Title	Deadline 4 Noise Responses		
Project	Gatwick Airport DCO		
Reference	28AD.NT.5.0	Author(s)	BHo
Date	30 May 2024	Reviewer	VC

1. The Applicant has updated their proposed Noise Insulation Scheme [REP4-017]; this note sets out further clarifications sought. **Table 1** sets out summaries of issues identified by Suono.

Centre OS Grid Reference: E:527310, N:140941

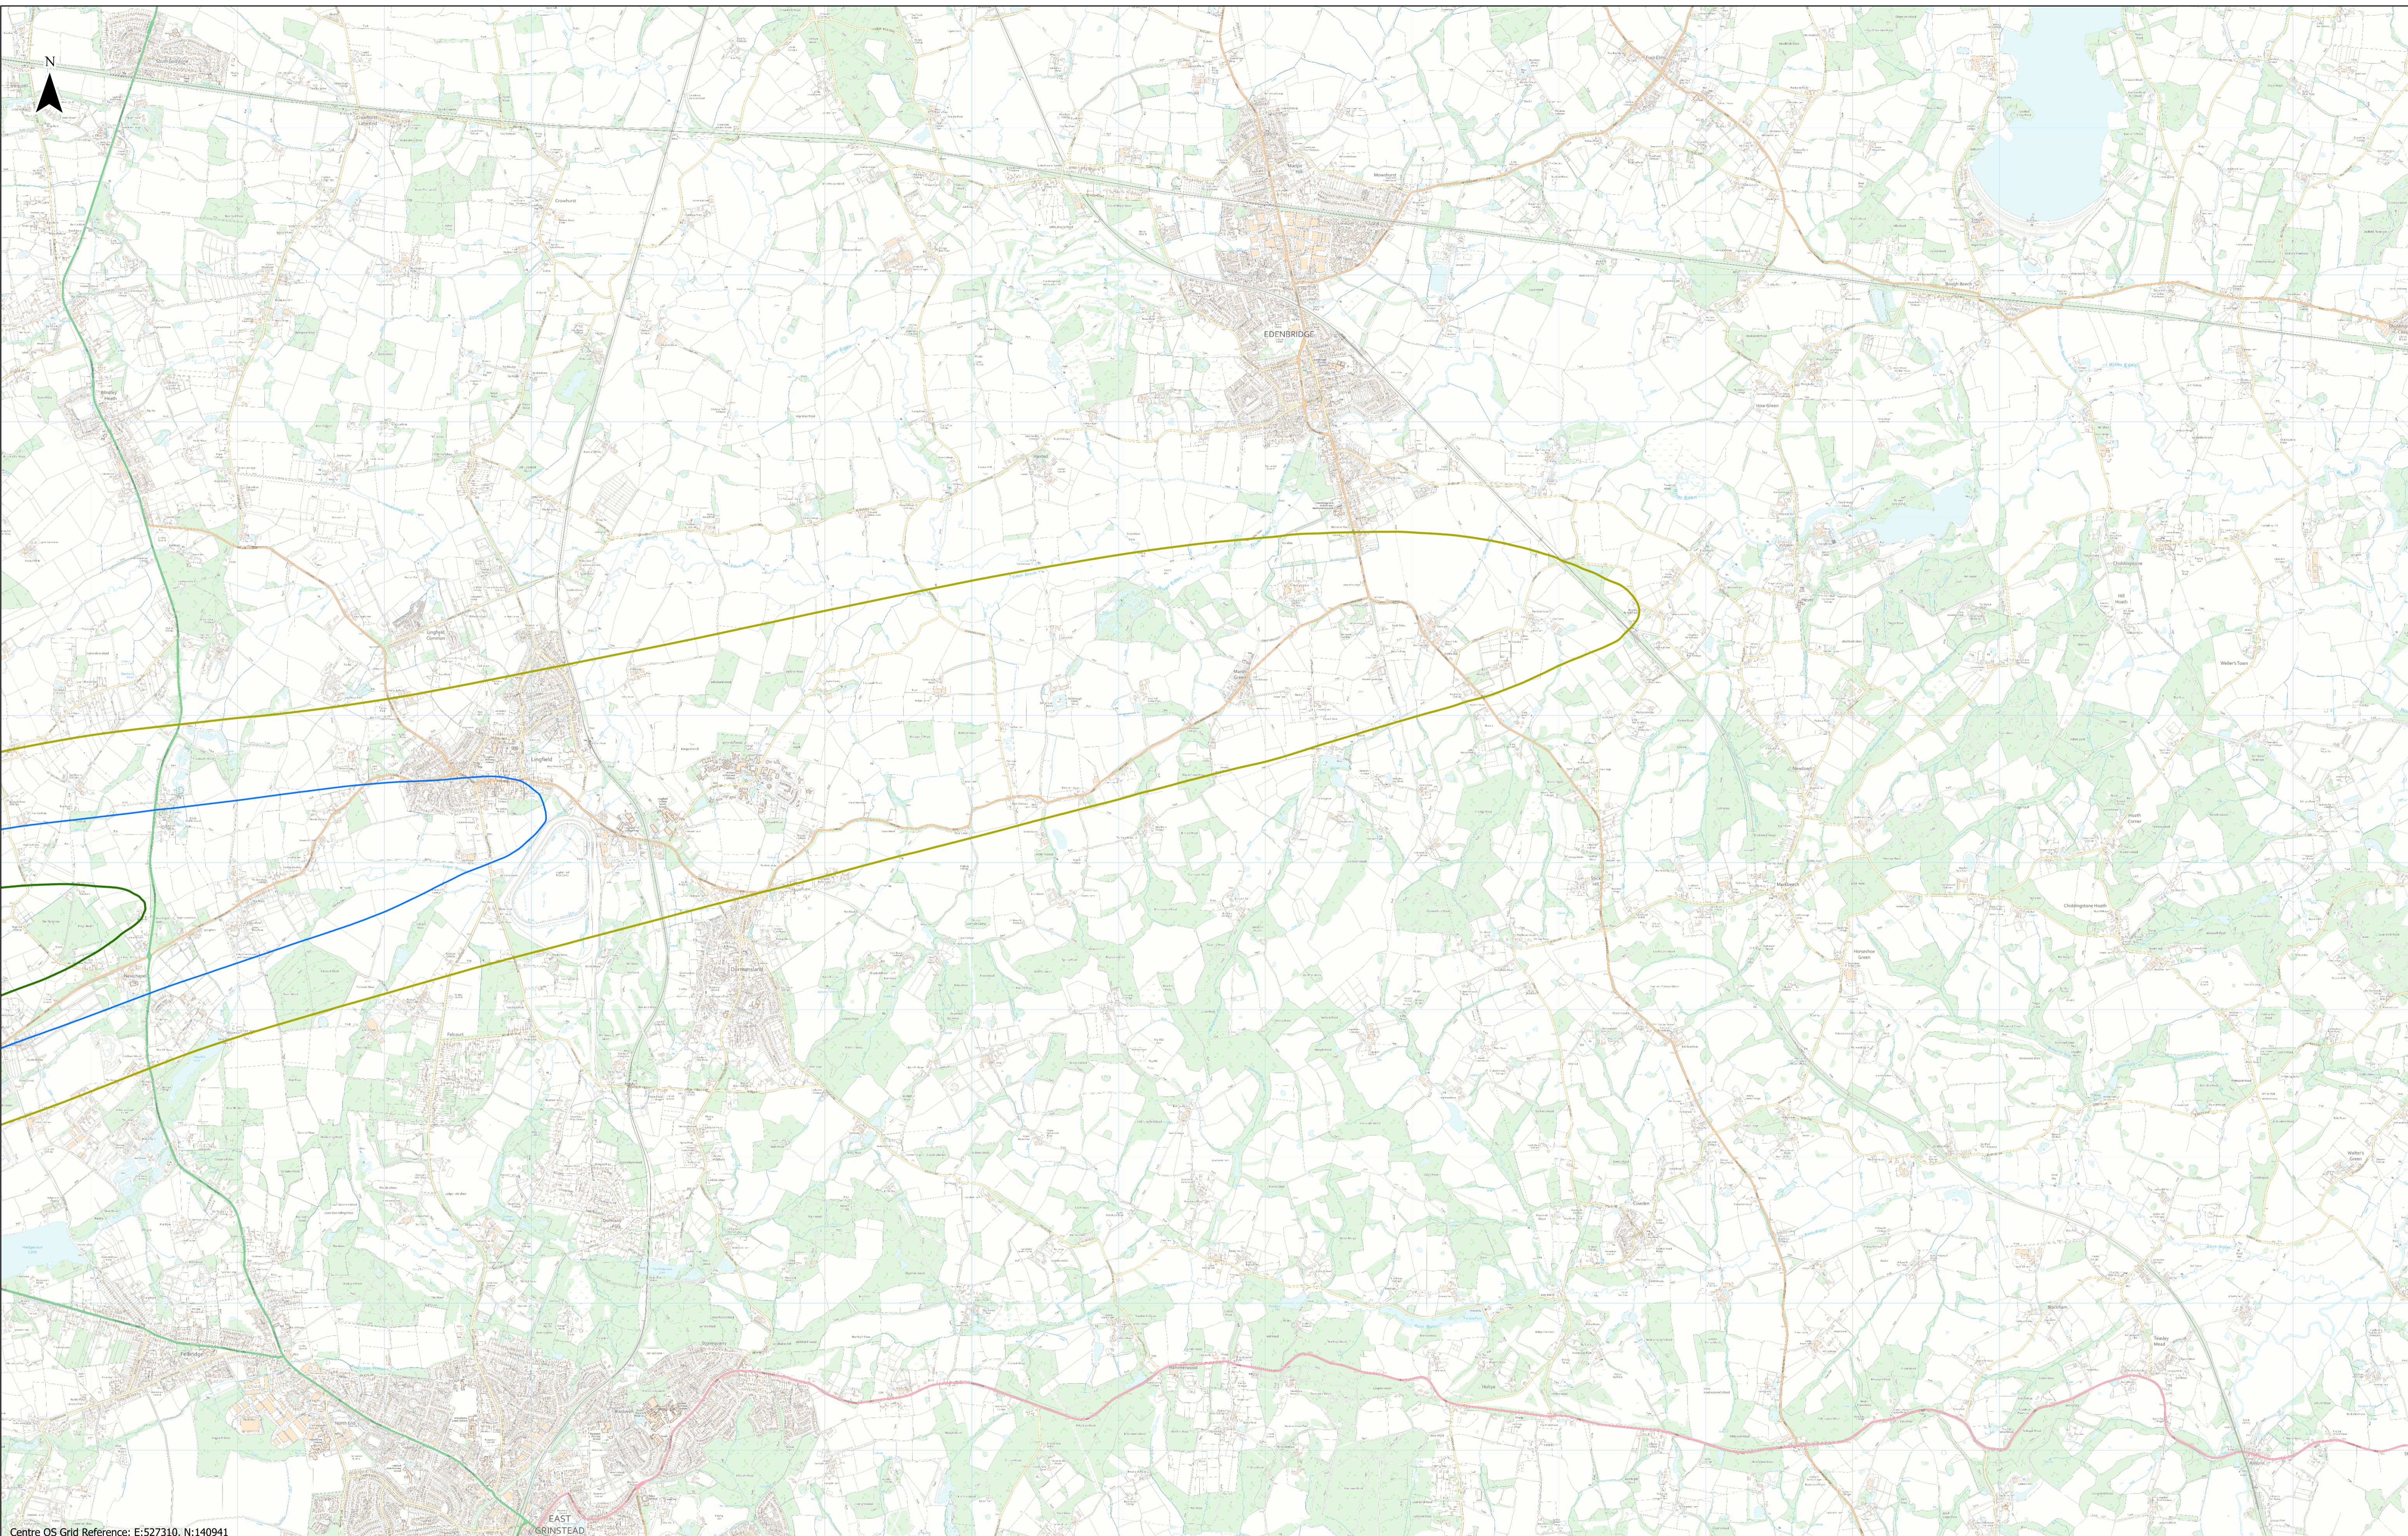
The SOAEL contour figures provided in in Appendix 2 of Appendix B in REP3-071 would suggest both Oakfield Cottages and Lowfield Heath fall just outside the Inner Zone and would likely be inside the Outer Zone and as such are eligible for noise insulation at a far earlier stage than when the Applicant proposes to review the matter.

Untitled contour figure on final page. The figure should be replicated on a map where dwellings are clearly identifiable, to demonstrate which could benefit from mitigation. A website is not a suitable replacement, as this is not traceable in the same way as submitted documents are.

The Zones should also be expanded around settlements bisected by the Zones' boundaries. This would help ensure that certain situations do not occur, such as residents living on either side of the road receiving differing levels of mitigation, or some receiving mitigation while their neighbours do not.
